DOC20/962468

20 November 2020

**Sydney Metro – Western Sydney Airport (SSI 10051)  
Advice on Environmental Impact Statement (EIS)**

Figure 16-2b

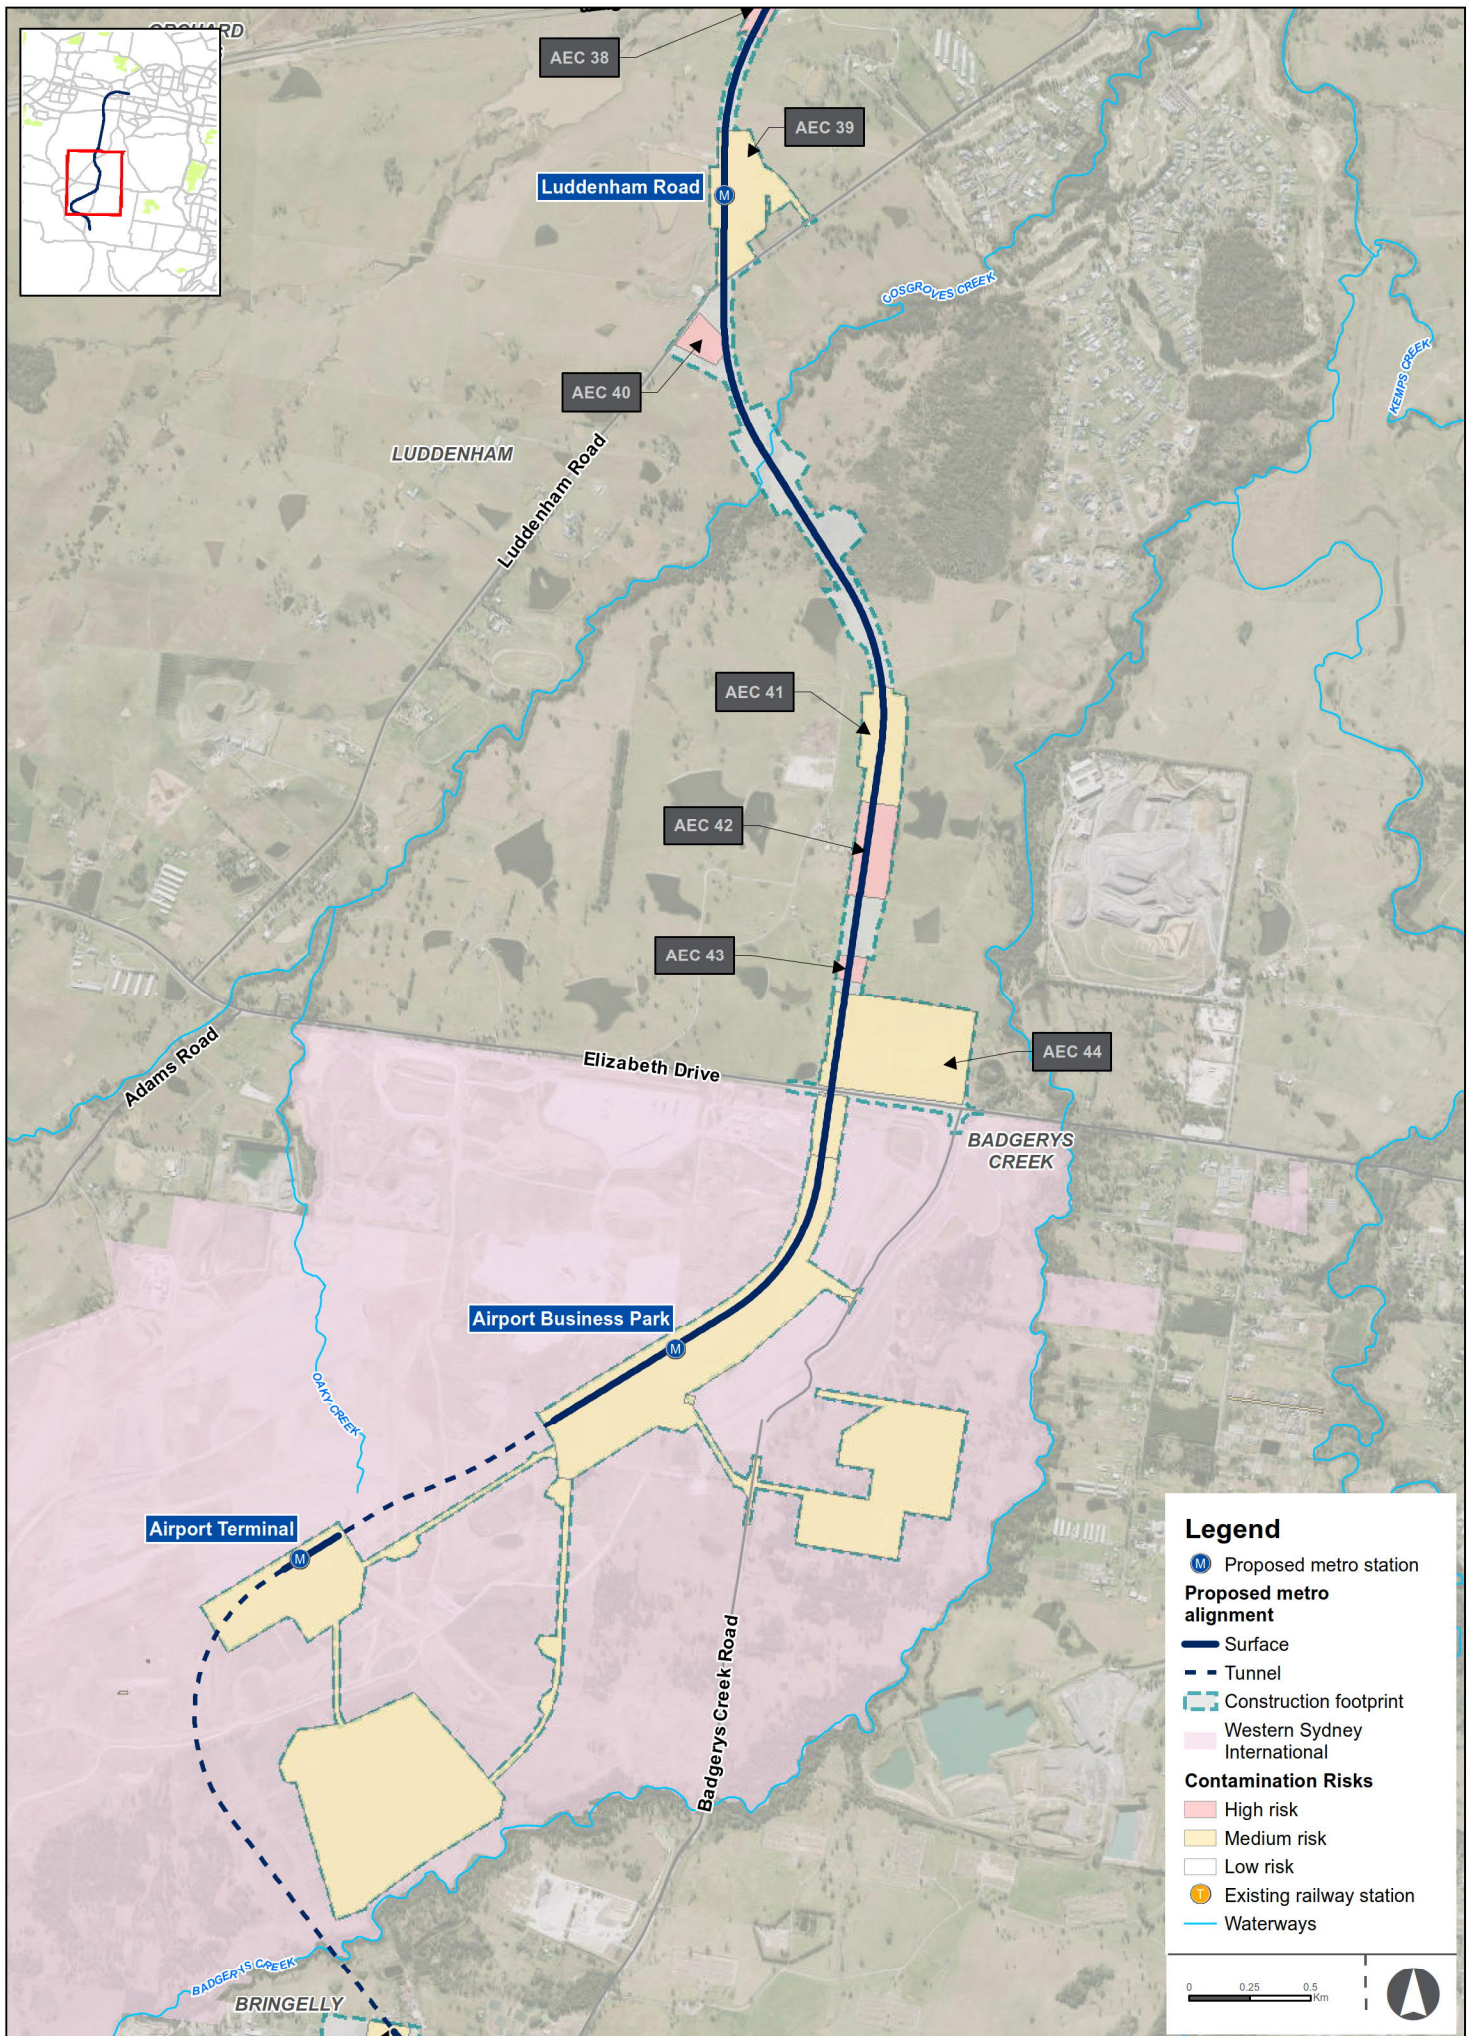
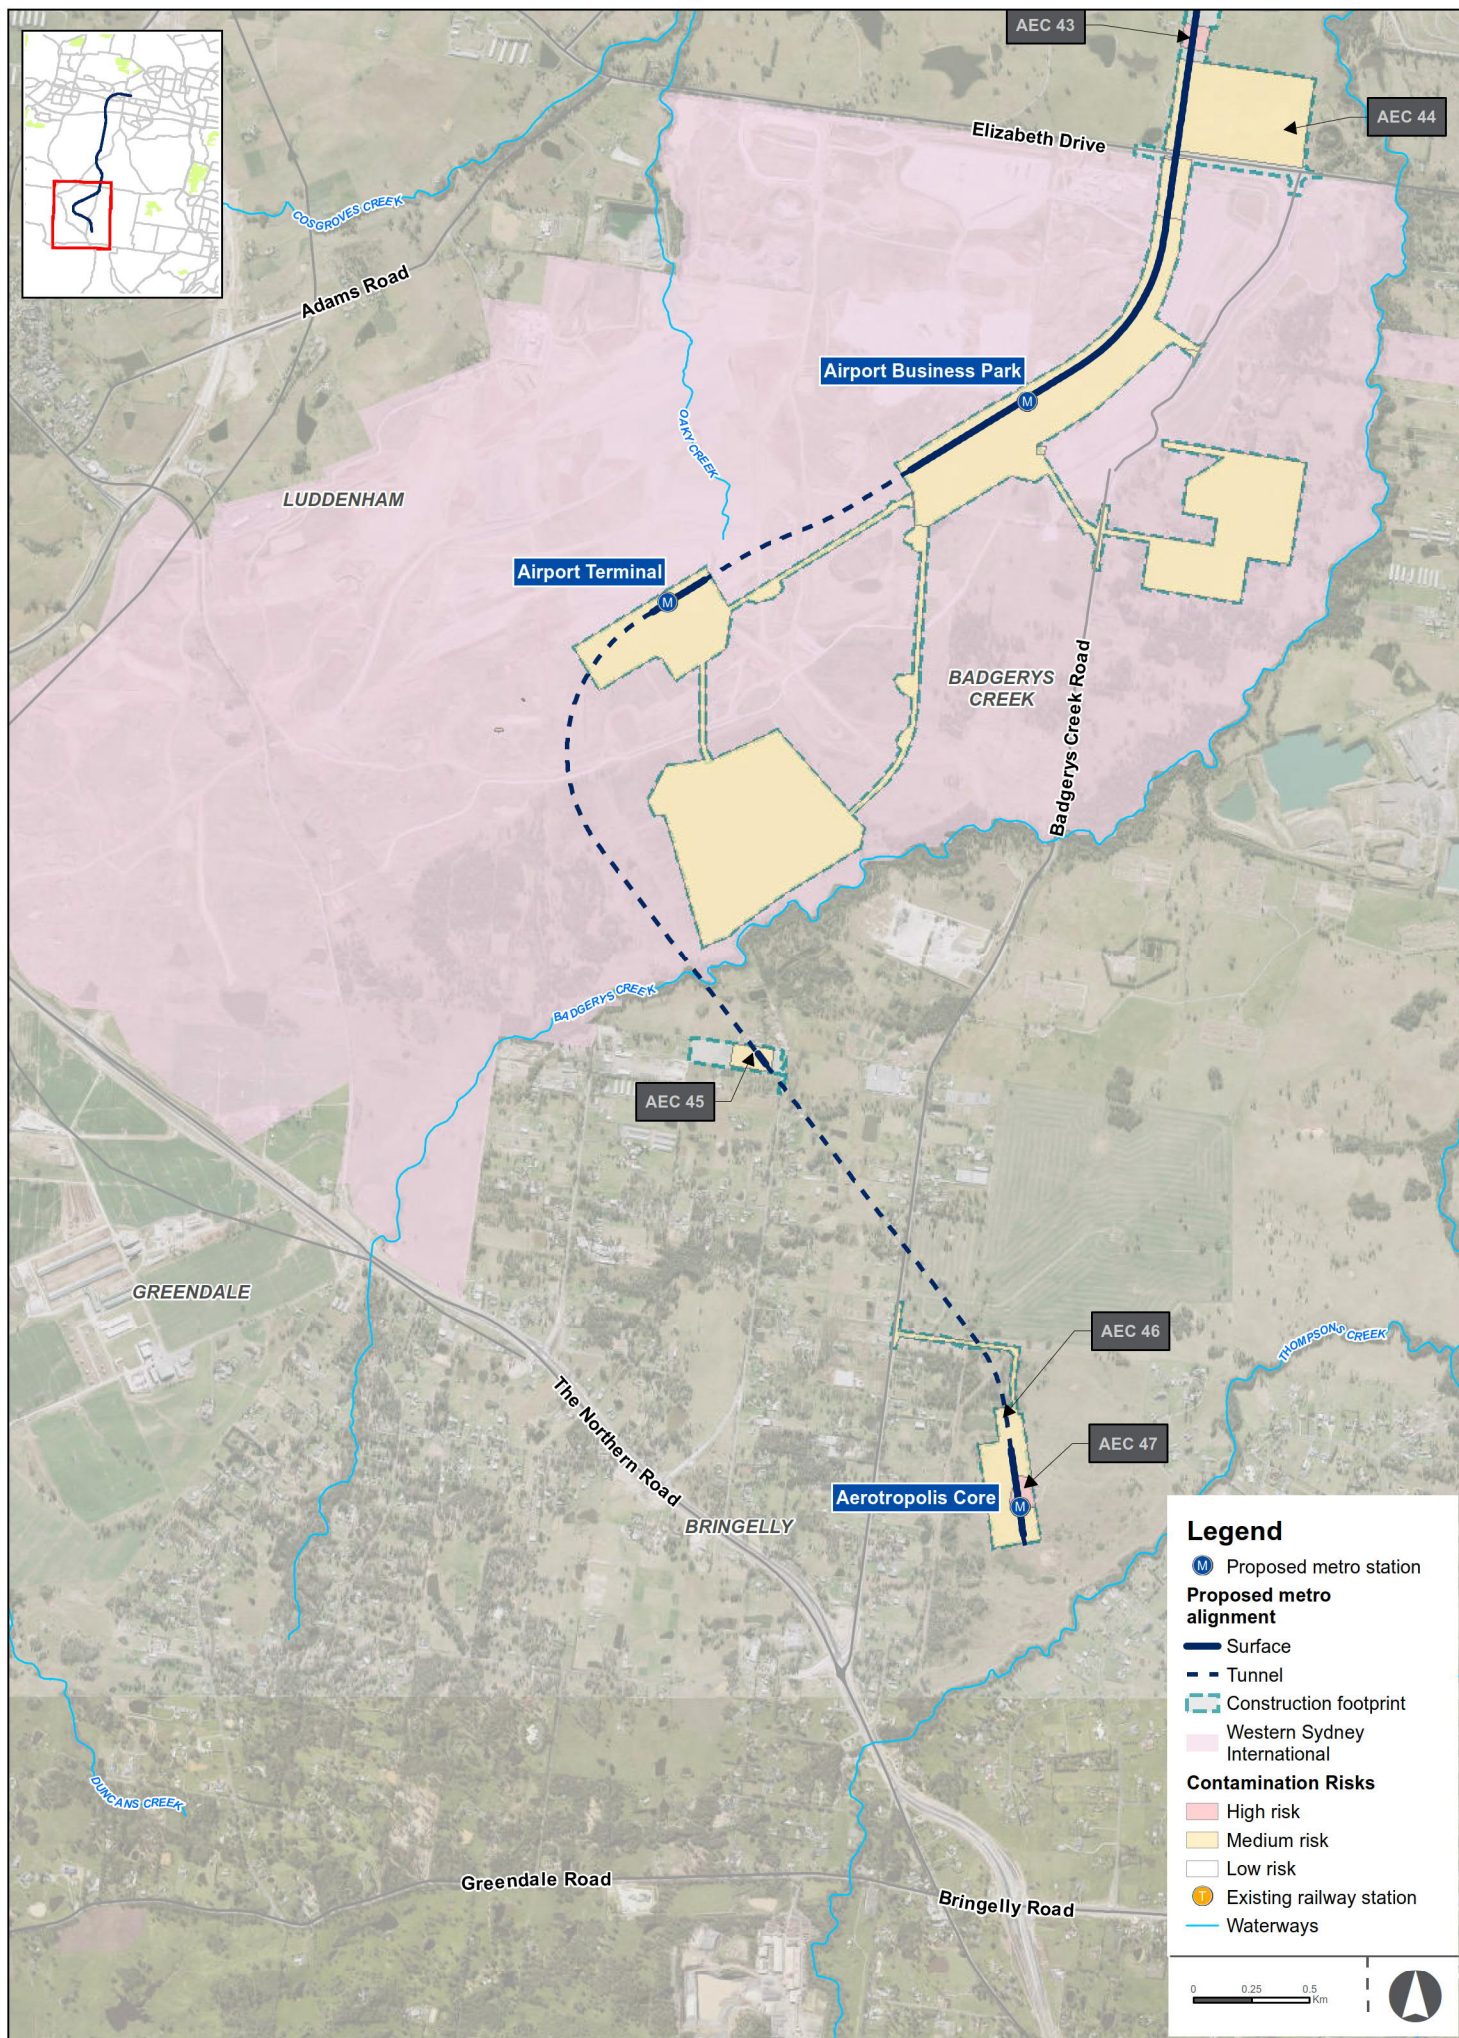
The contamination technical paper (TP8) provides a desktop study that identified over 50 areas that could present potential risk to human health and/or the environment from contamination. **These areas of potential contamination must all be addressed to ensure the site is made suitable for the proposed uses.**

The SEARs requirement to verify the risk of land contamination and identify if remediation of the land is required has only been partly addressed. Further investigations are required to verify the risks from land contamination and determine whether remediation is required

Given that further investigation, risk assessments and likely remediation is required as well as mitigation measures during construction to ensure that contamination is appropriately managed, **the EPA recommends that a NSW EPA-accredited site auditor is engaged throughout the duration of the works.**

To demonstrate that a site auditor has been engaged, as part of the RtS, it is **recommended the applicant submit an interim audit advice** from a NSW-accredited site auditor commenting on the nature and extent of the contamination for each area of environmental concern.
